March 13, 2017

Re: Restaurant and Mercantile Fit-Up, 6 City Center

Portland, Maine

Please see the answers below and attachments to address your comments.

DRAWN BY: RRT, RJS

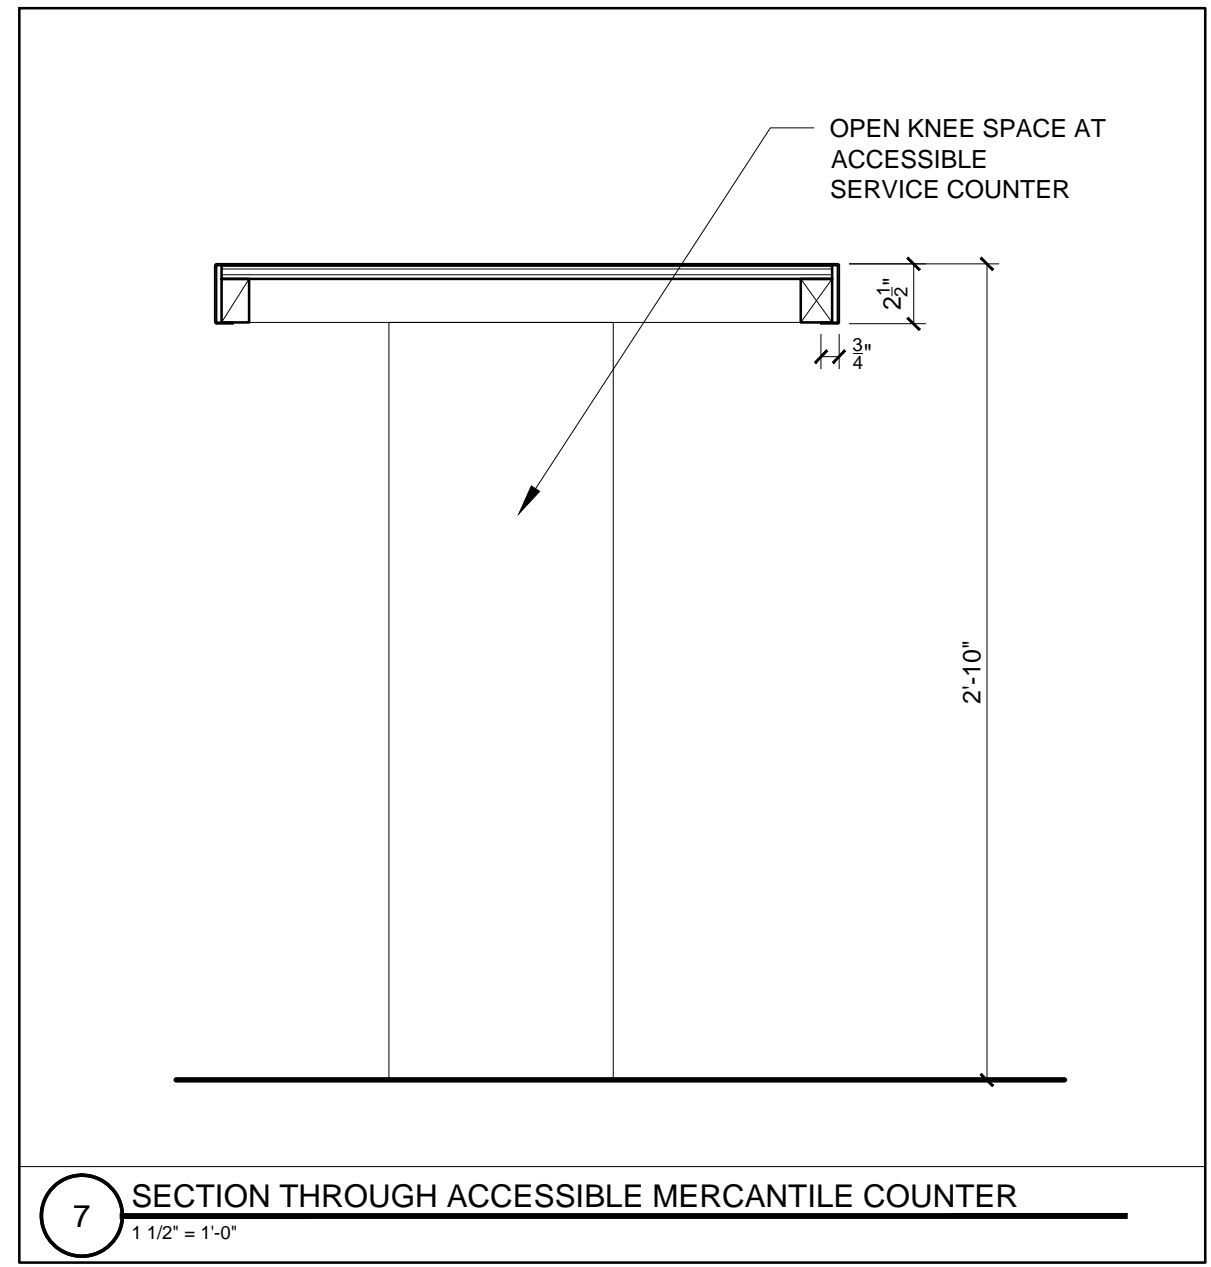
A5-0 See the attached revised drawing sheet with details 6 and 7 showing sections through the Accessible Bar and Mercantile counter area
